SANDSTONE PRECINCT

DESIGN REVIEW PANEL - ADVICE 13

13 July 2020

TITLE
**PROPOSED ELEVATIONS - LANDS BUILDING
- NORTH, EDUCATION BUILDING - NORTH**

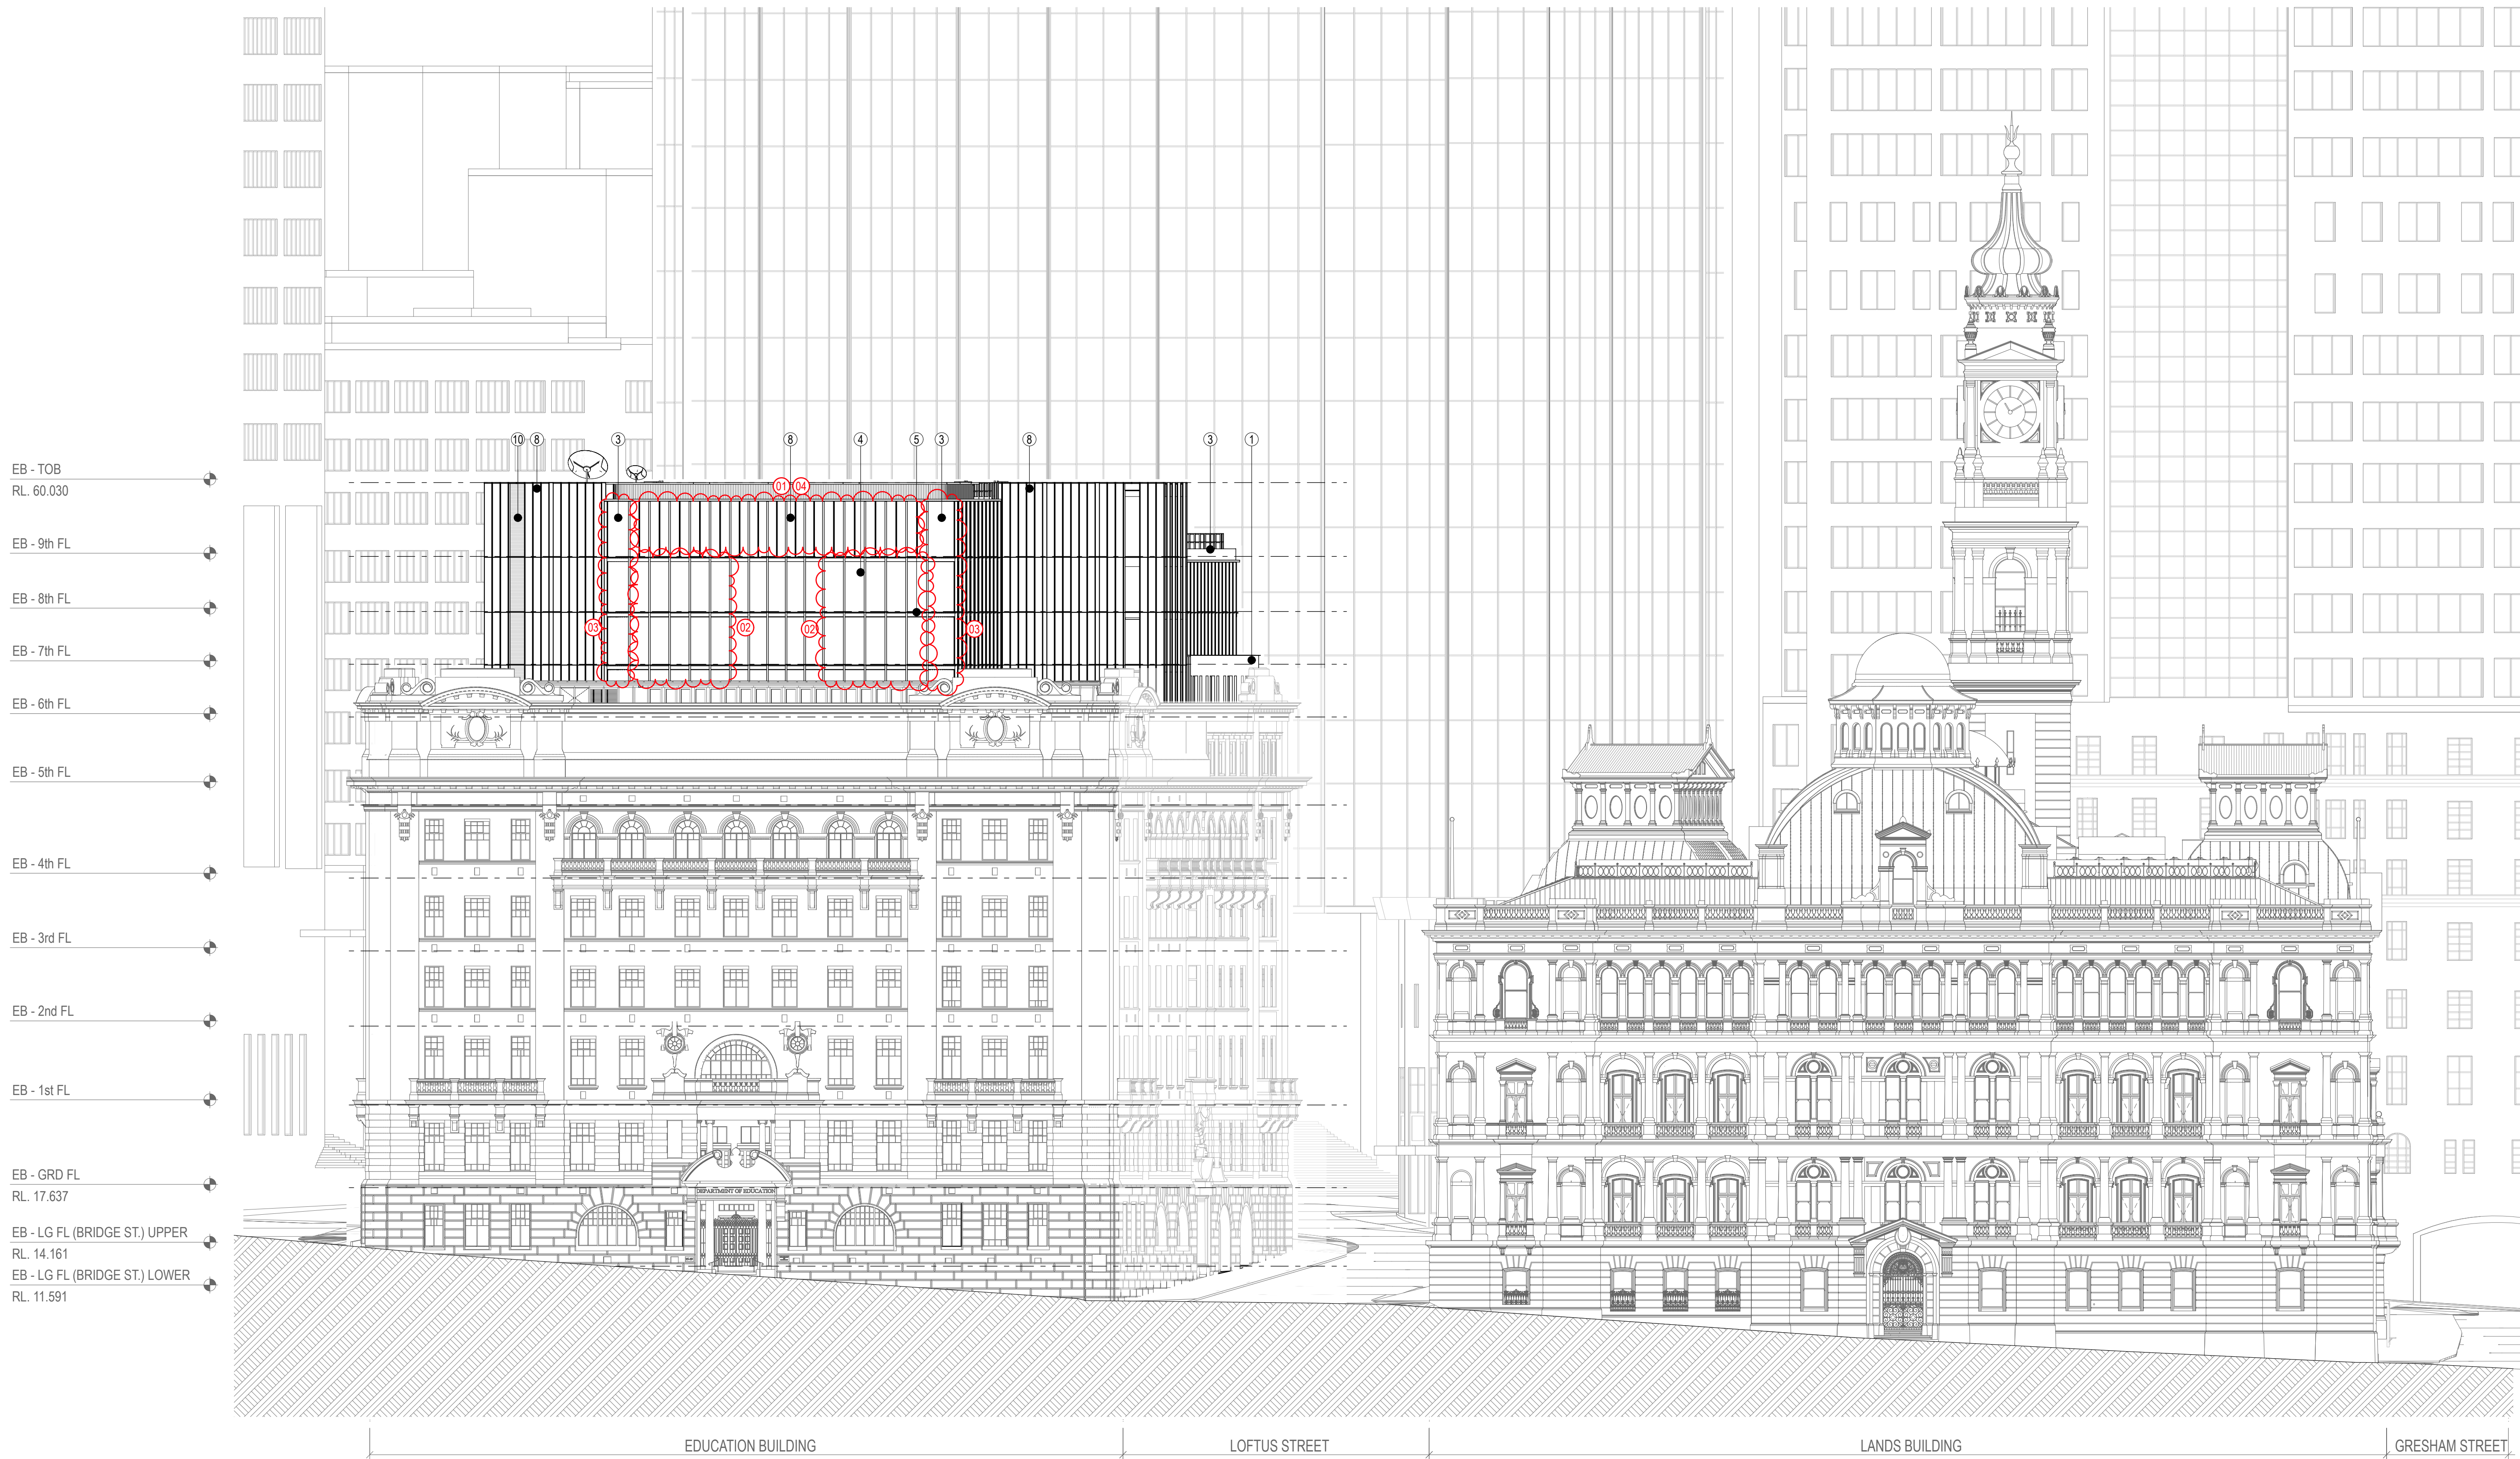
- . *Curved glass radius increase to 1500mm (External and Internal) & Mullion adjustment around curved glass corners.*
- . *External North elevation changes to cladding on level 9*
- . *External East elevation hidden door relocation on level 9*

The Panel supports these changes.

TITLE
PROPOSED ELEVATIONS - EDUCATION BUILDING - COURTYARD

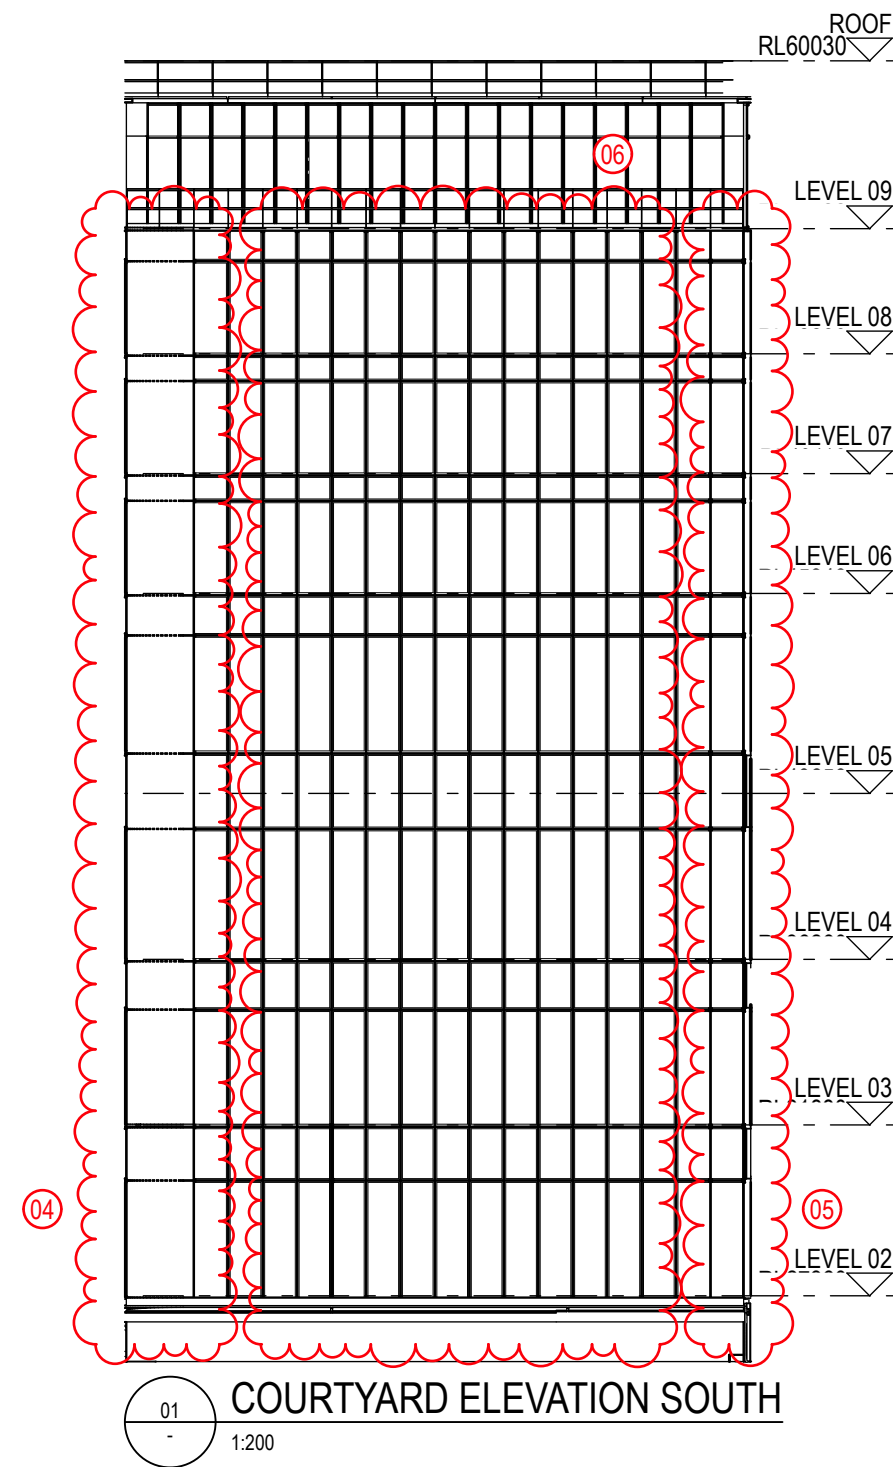
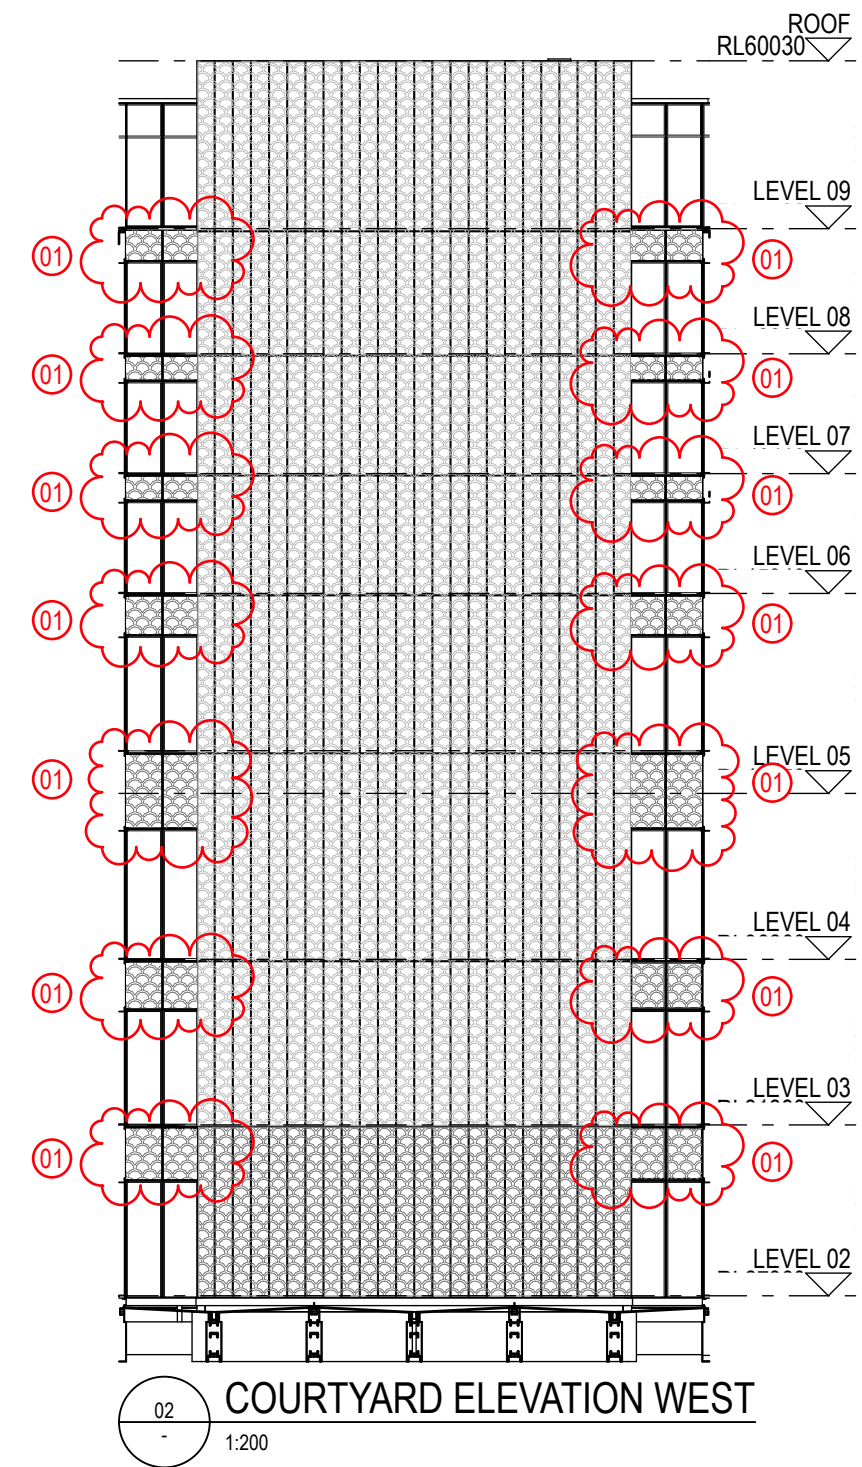
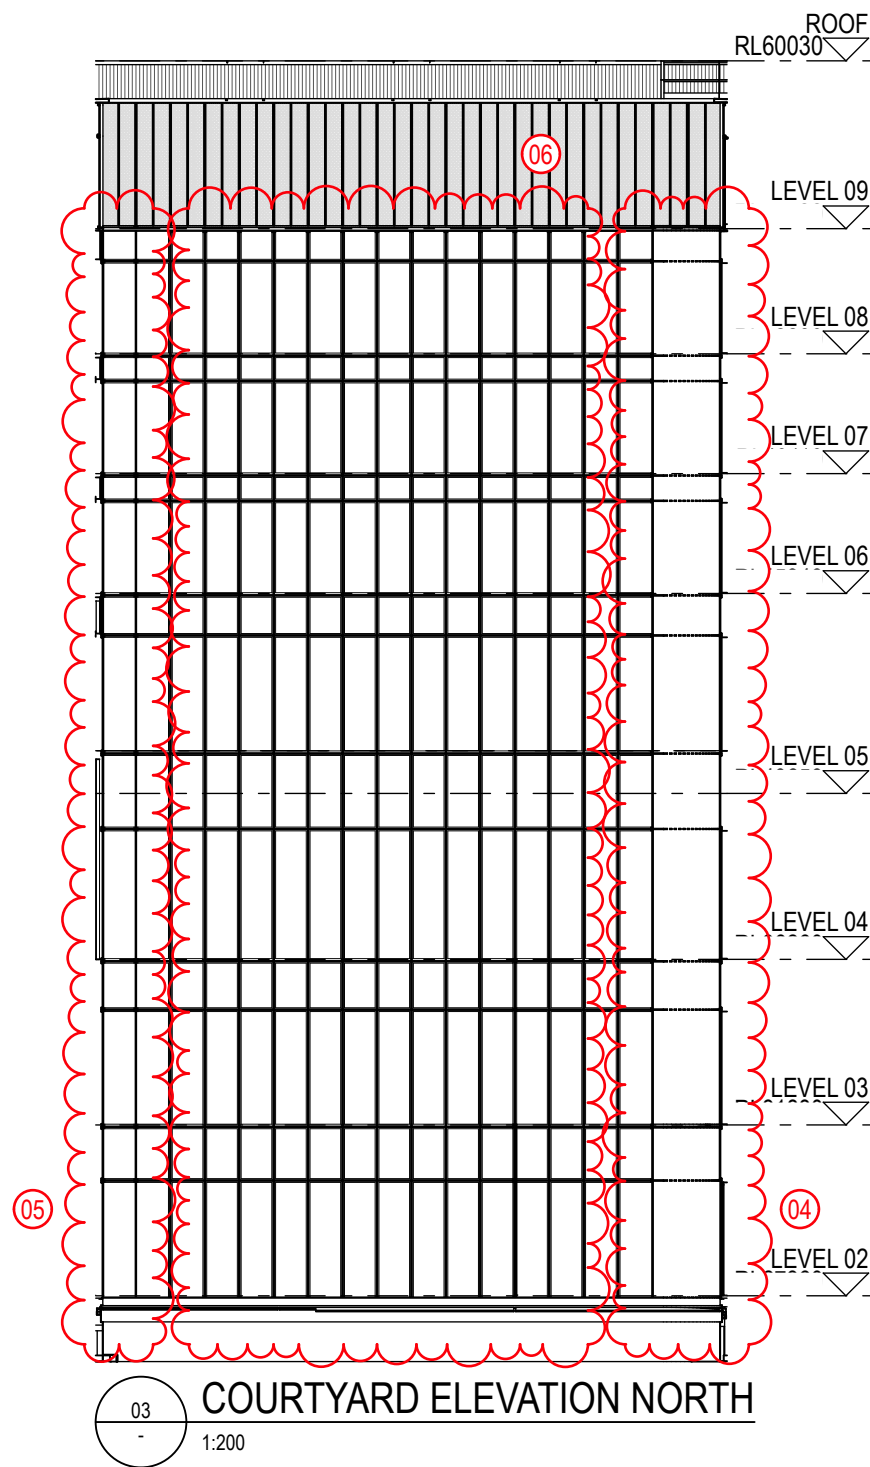
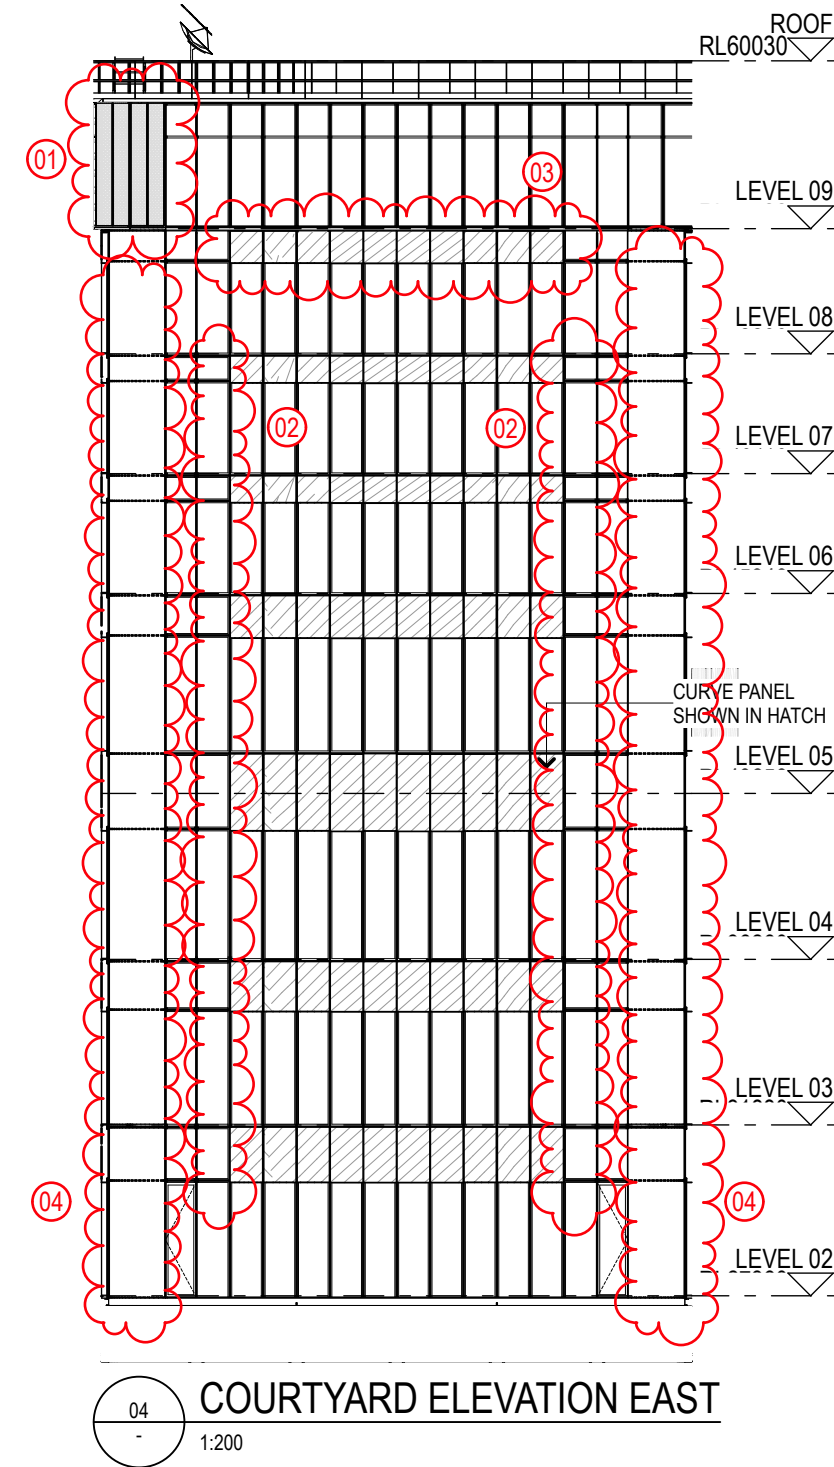
- . *Increased radius of curved glass to 1500mm and removal of West curved glass*
- . *West Elevation - Changes to louvres and spandrels in courtyard*
- . *East Elevation - Changes to louvres and hoods in courtyard.*

The Panel supports these changes.
